Application by Highways England for an Order Granting Development Consent for the A38 Derby Junctions Scheme
The Examining Authority's first written questions and requests for information
Issued on Friday 11 October 2019.

The following table sets out the Examining Authority's written questions and requests for information to assist with the assessment of the application.

Figure 8a: ARN for Construction Phase Scenario 2- Change in HDV Traffic Flow

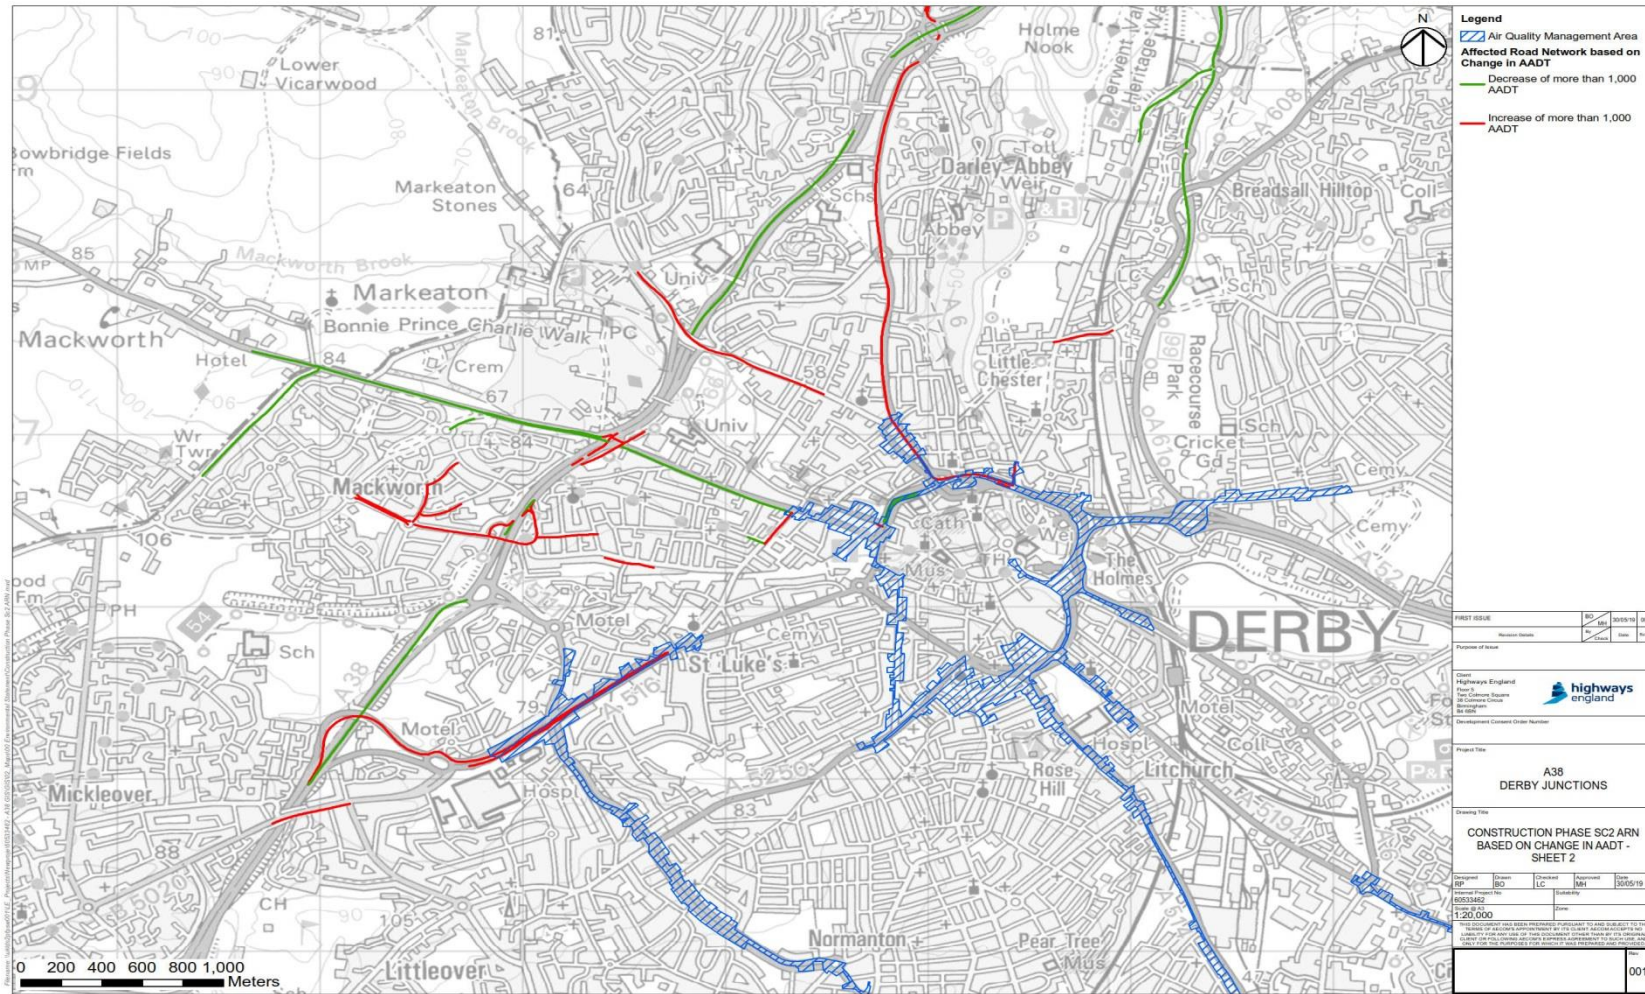
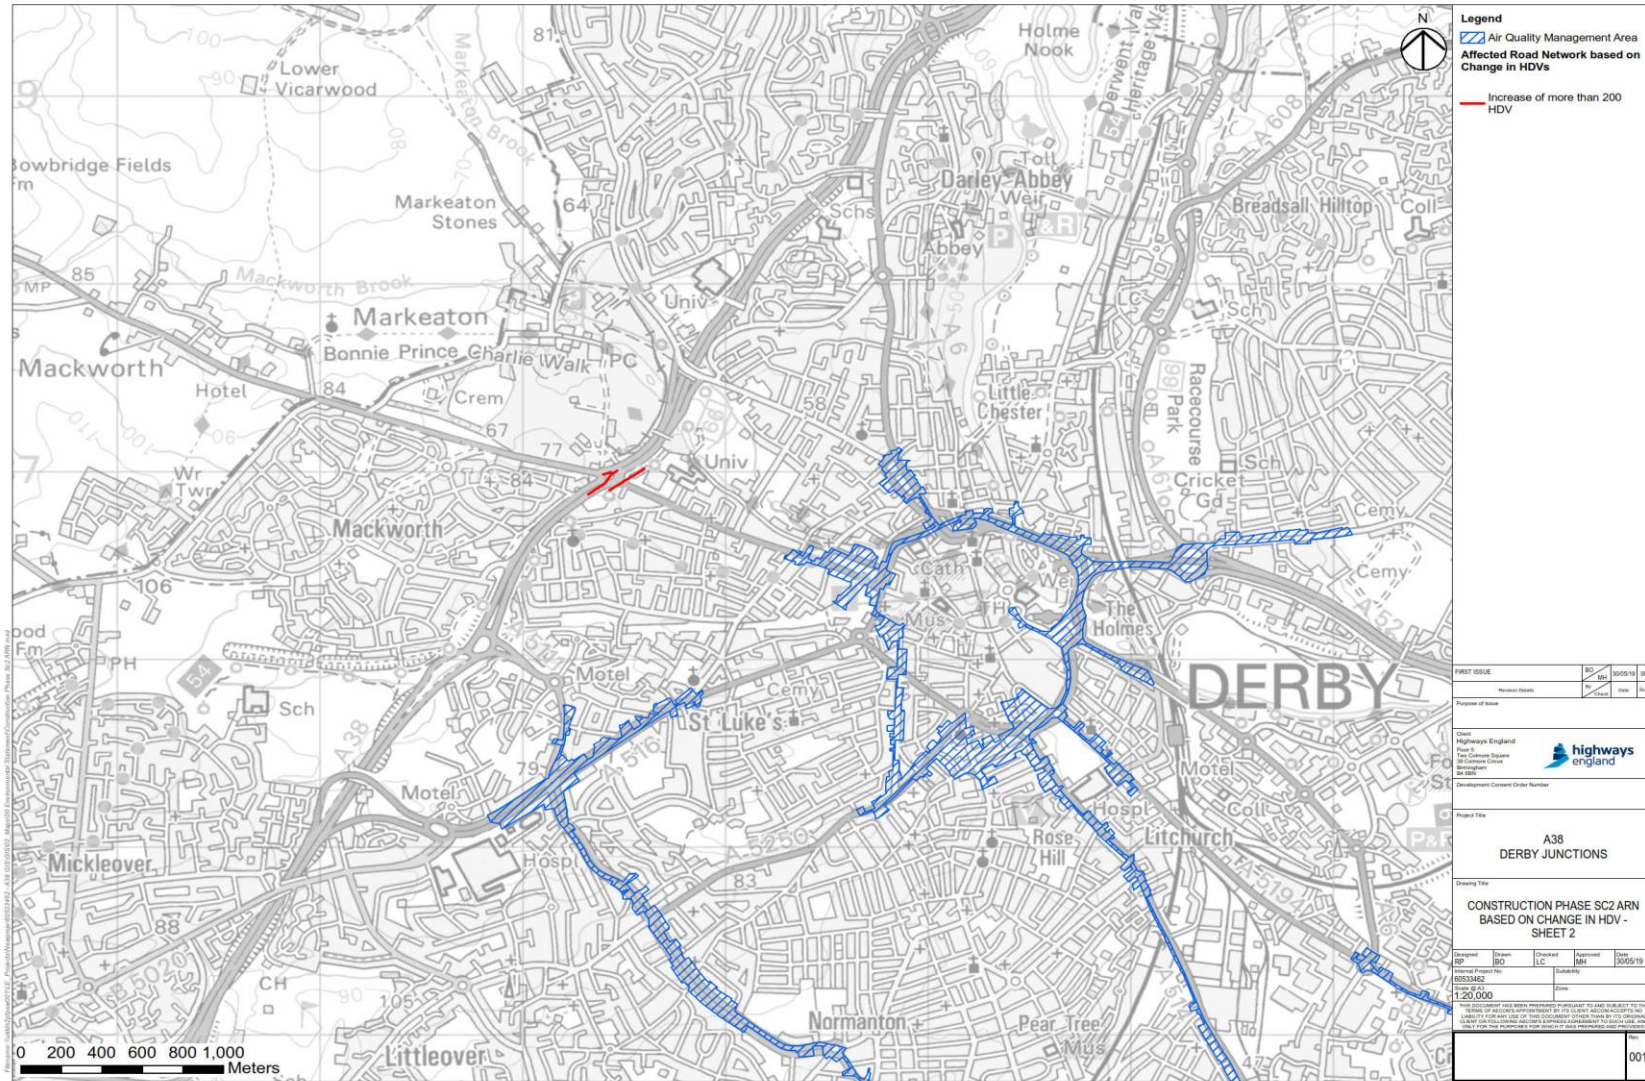
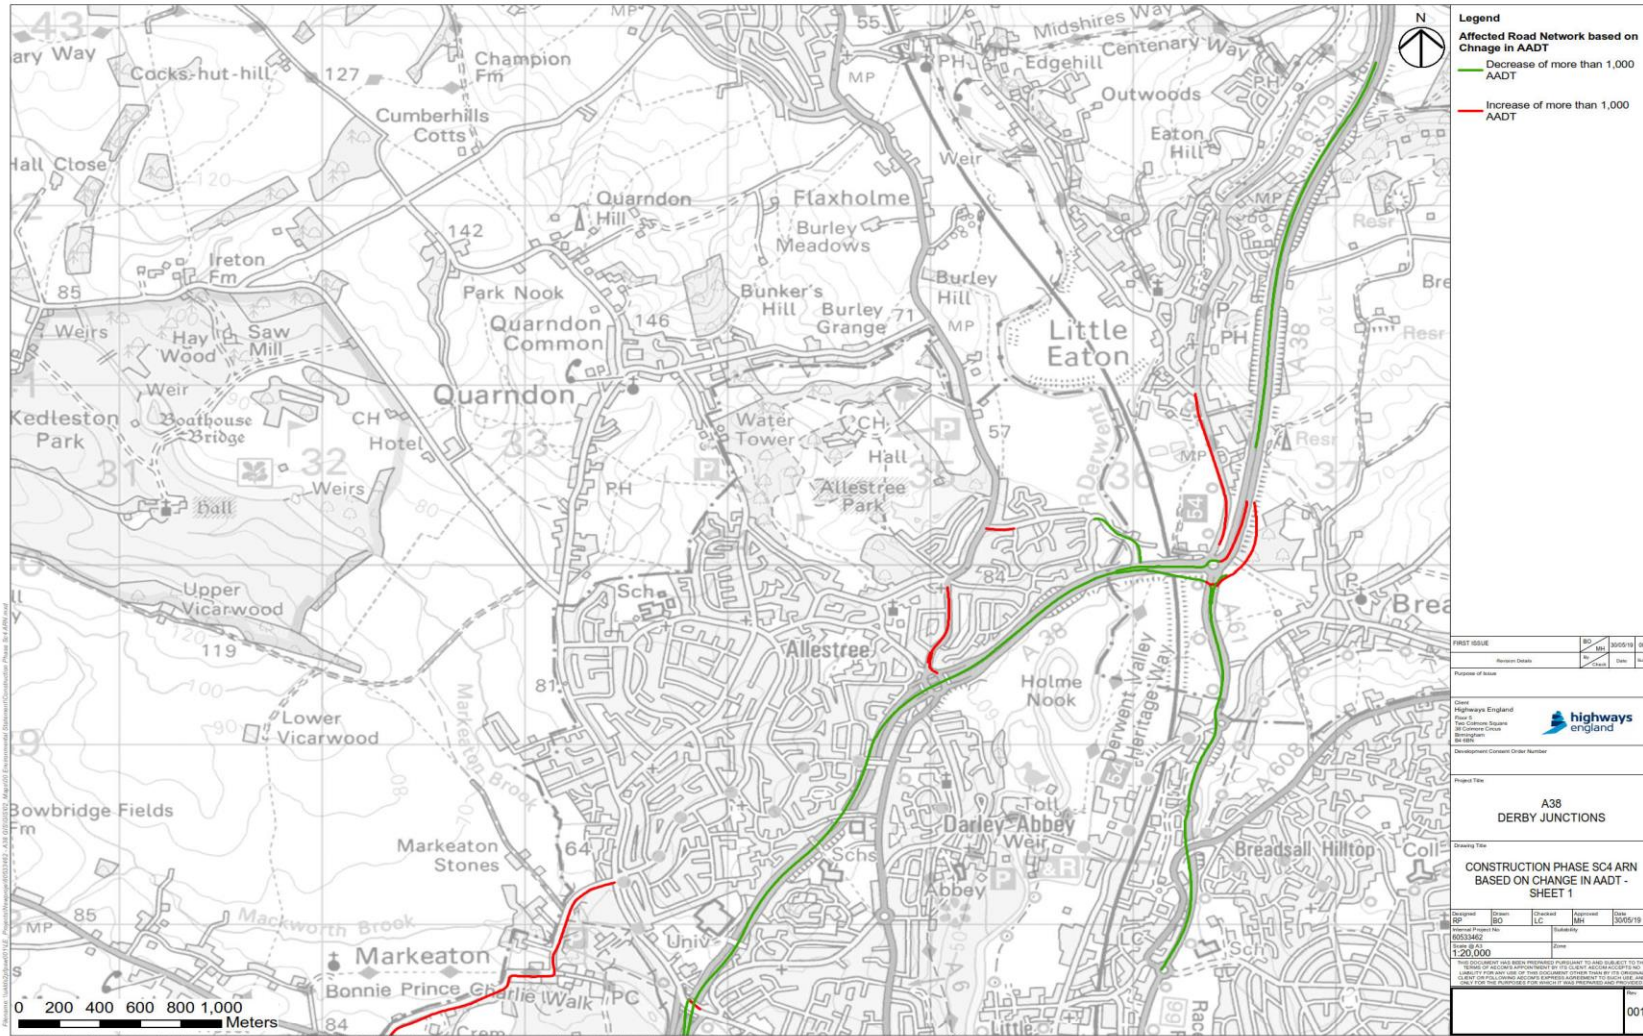
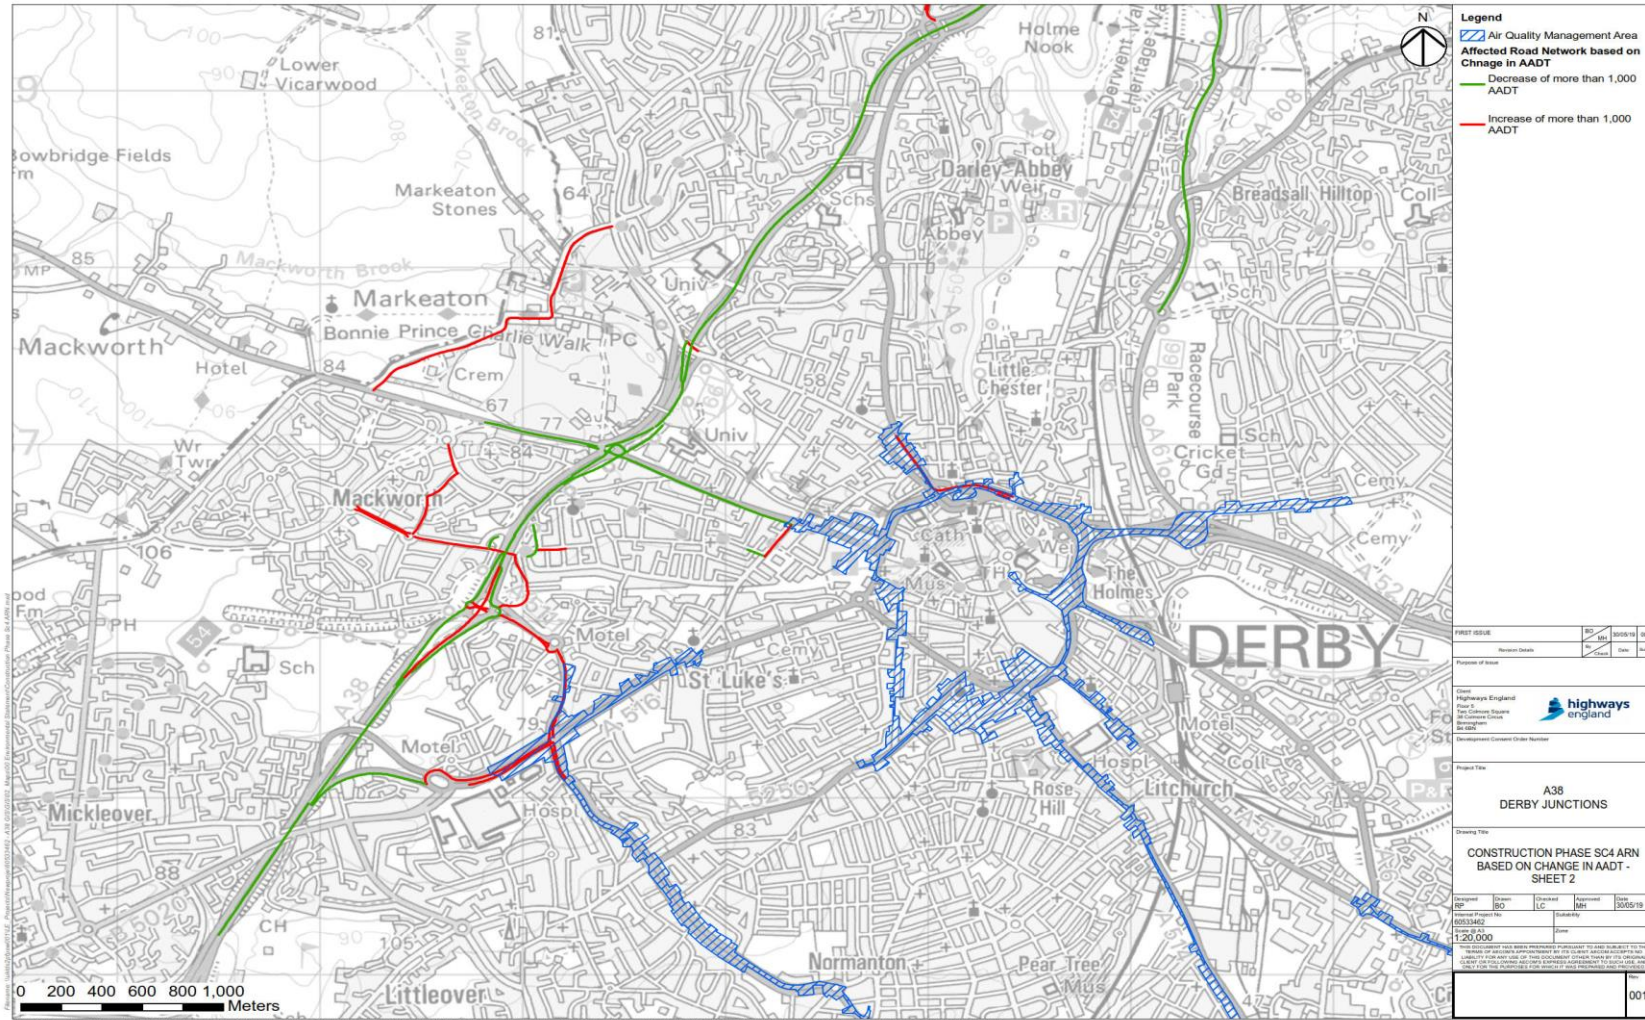
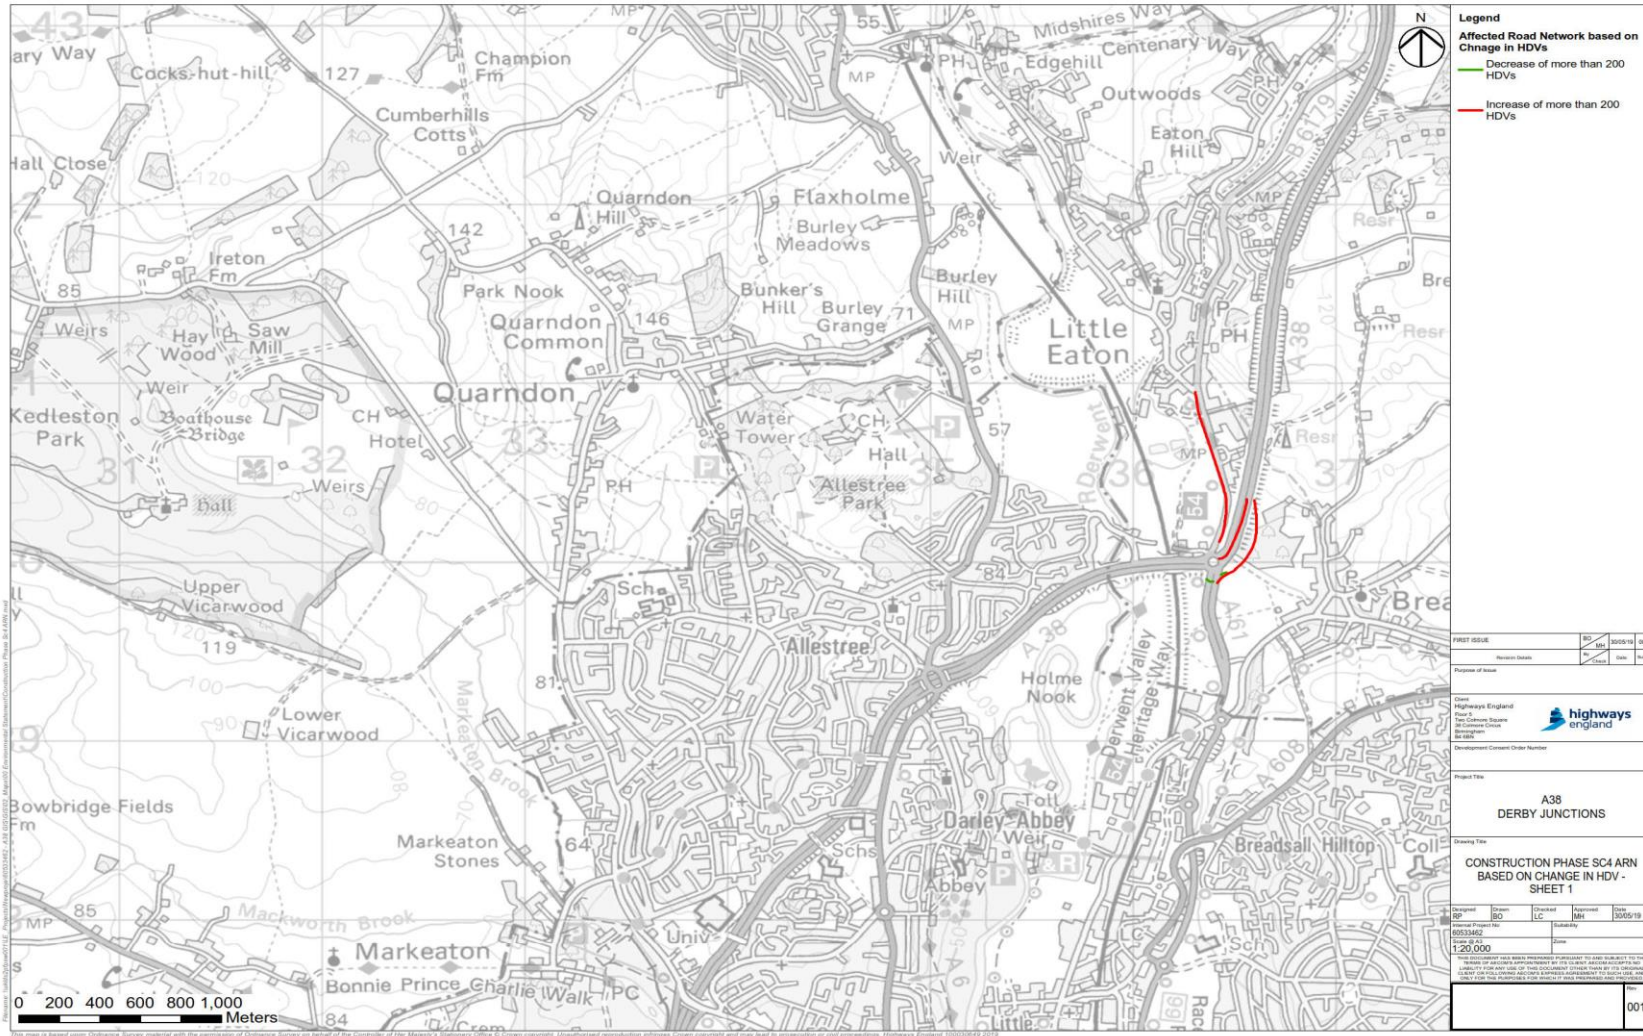
5. Air quality			
Baseline conditions and overall assessment methodology			
5.1.	Applicant	Details of exceedances of air quality screening criteria at affected road links.	The Applicant was issued with s51 advice on 22 May 2019 requesting further information regarding the screening process for inclusion of receptors/road links on the affected road network for further consideration in the assessment. In its response [AS-013] the

No	Question to	Reference	Question
			<p>Applicant provided updated figures [AS-006] to illustrate affected road links. However, detailed information demonstrating how the air quality screening criteria are exceeded were not supplied.</p> <p>Please provide specific details of how the affected road links exceed the DMRB screening criteria during both construction and operation or signpost to where this may be found in the application documents.</p>
